**Consultation Response from KC,
Trees**

2025/90352 adj, 33a, Church Lane, Clayton West, Huddersfield, HD8 9LY

Discharge of details reserved by conditions 6 (boundary treatments), 8 (intrusive site investigations and remedial works), 9 (declaration), 10 (Phase I Desk study Report), 11 (Phase II Intrusive Site Investigation Report), 12 (Remediation Strategy), 13 (Remediation Strategy), 14 (Verification Report) and 15 (Arboricultural Method Statement and Tree Protection Plan) of previous permission 2024/93464 for variation condition 2 (plans) on previous permission 2023/91483 for demolition of garage and erection of detached dwelling.

Date Responded: 6/3/26

Appendix 2 Tree Protection Plan

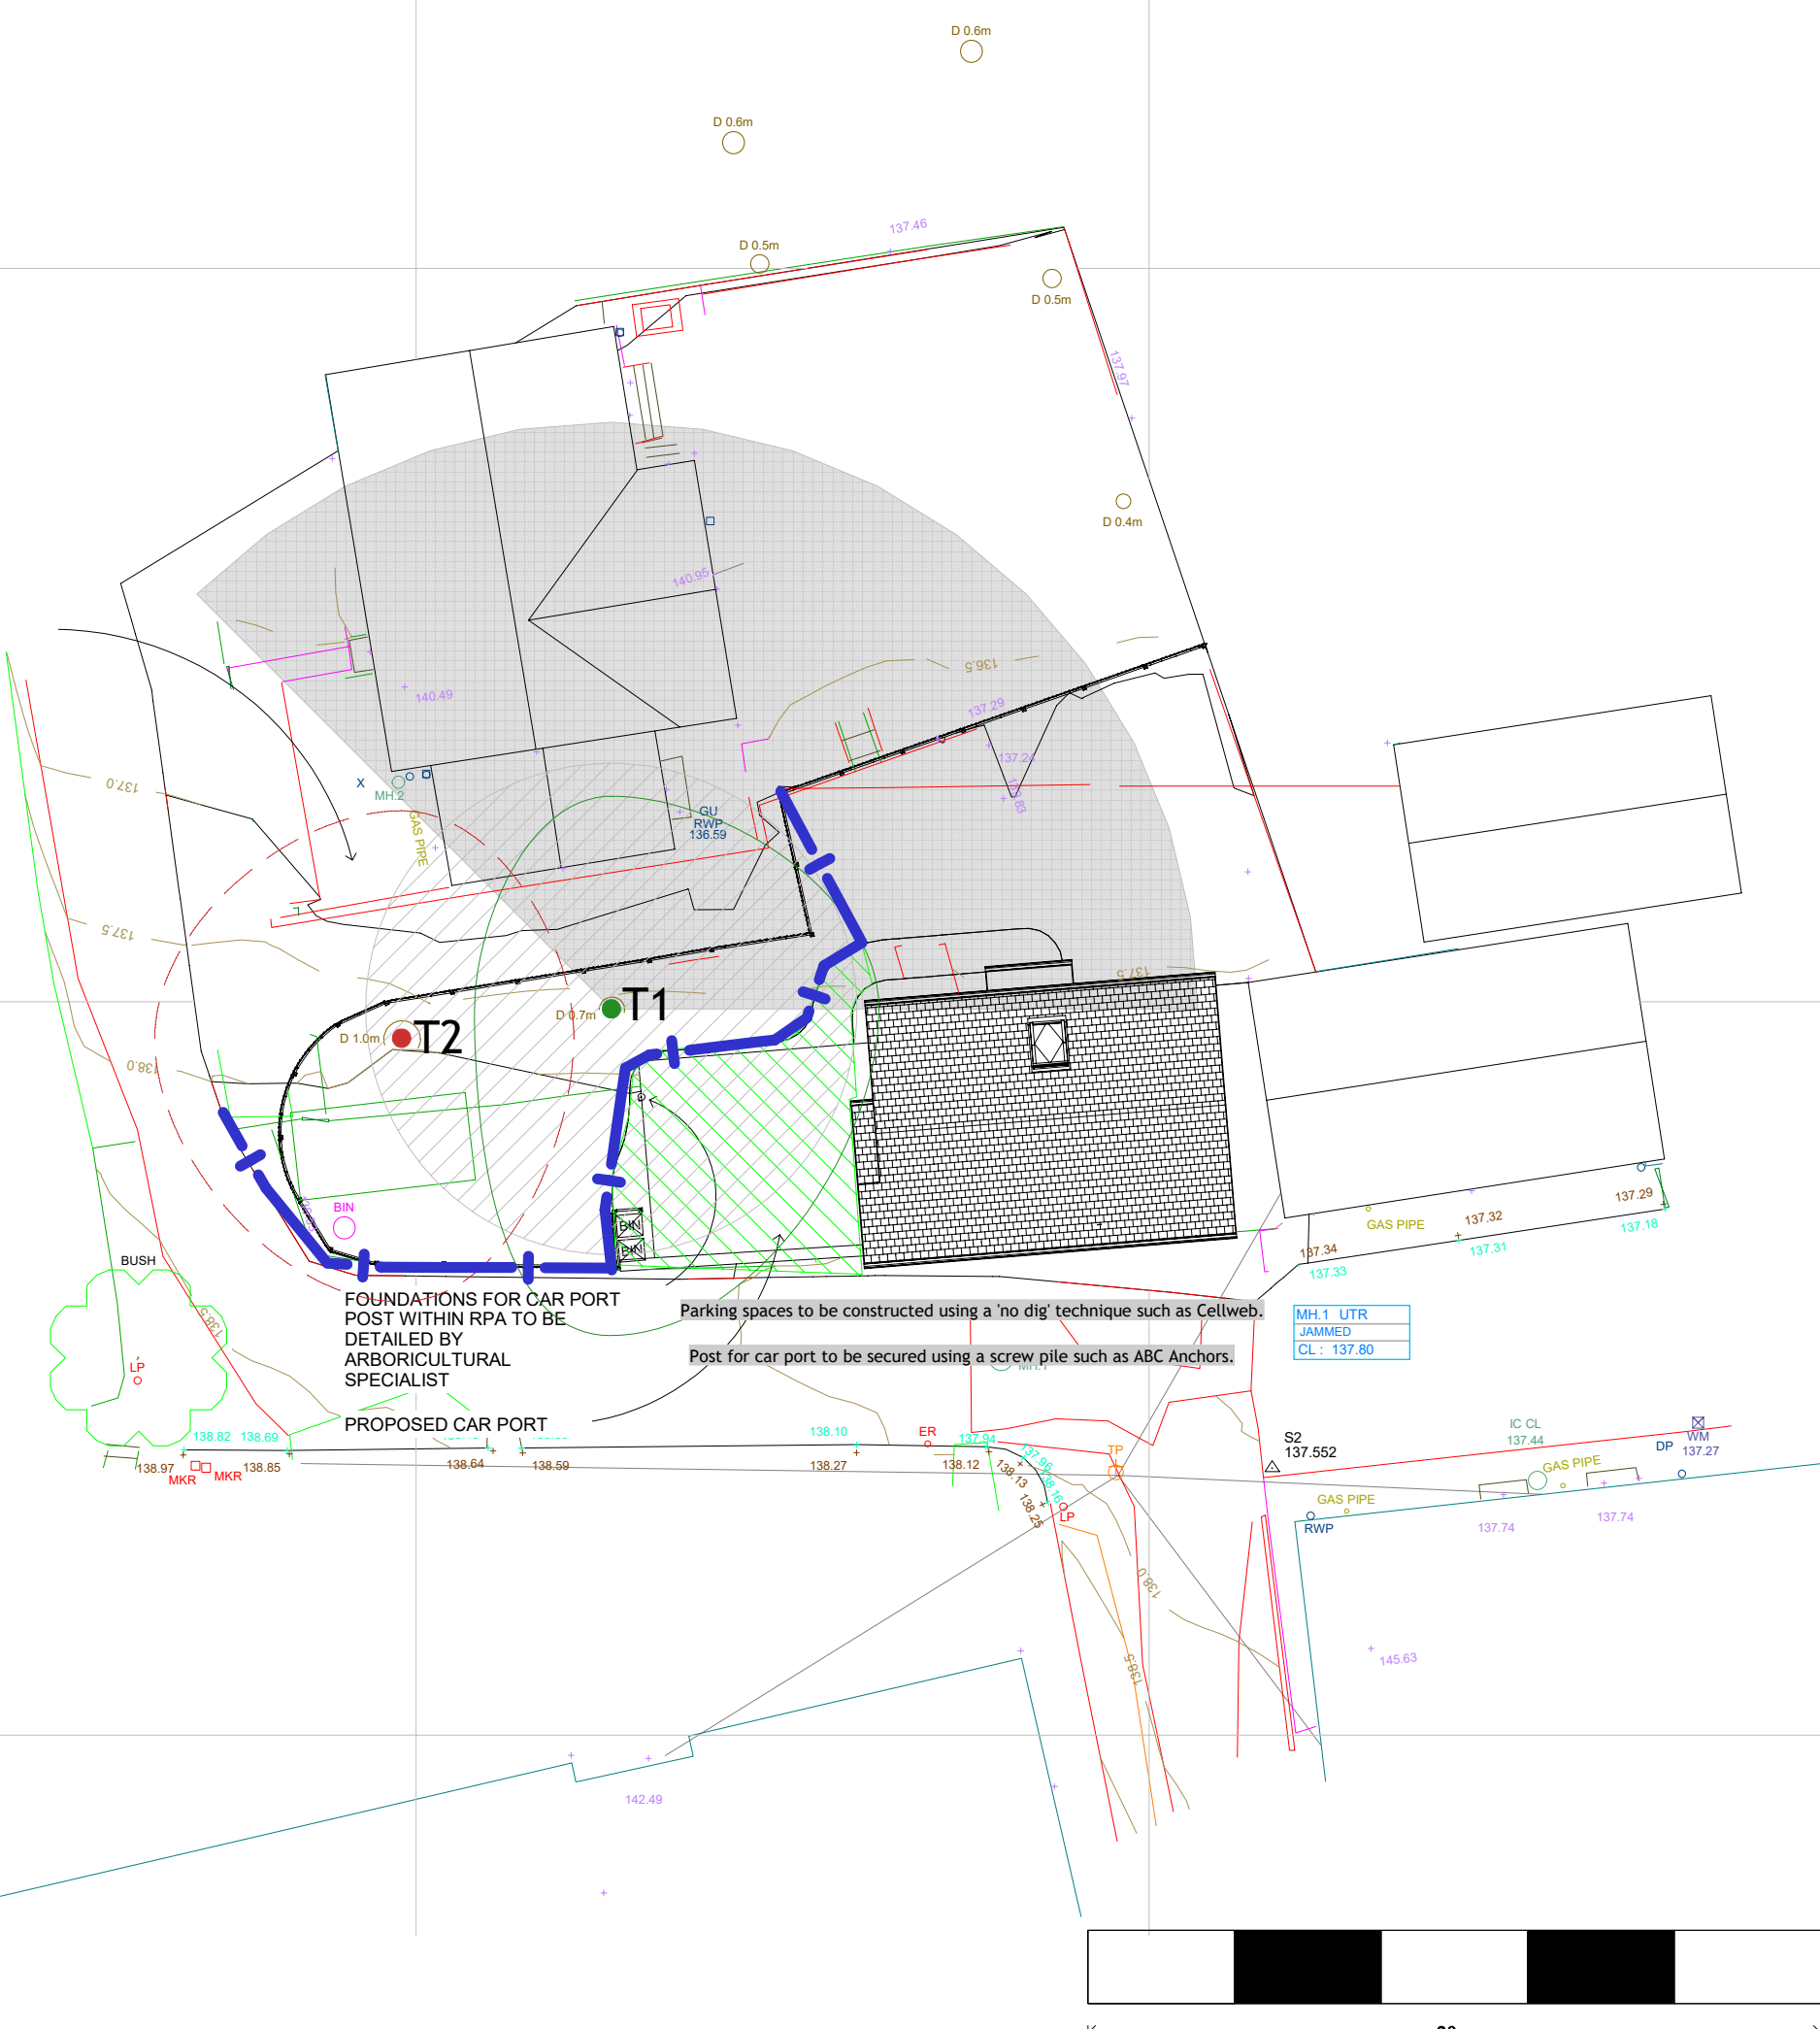
AMS ref 25_5837_07_112, dated 01/08/2025 has been rejected by KC trees. This AMS does not adequately protect the trees protected by TPO ref. 87/91. Protected tree T2 is marked as Category U on the Tree Protection Plan, indicating that it is unsuitable for retention. No evidence has been provided to show that the tree should be deemed a Category U tree and consent for its removal was refused in 2024.

It was previously agreed to amend the proposals to show T2 as retained and this was included and in application 2025/44/90352/E.

There is a holding objection from an arboricultural perspective. The proposal conflicts with adopted Kirklees local plan policy 33 and 24 (i). A new method statement must be submitted showing T2 as retained and demonstrate how T2 will be protected throughout the development of the proposals.
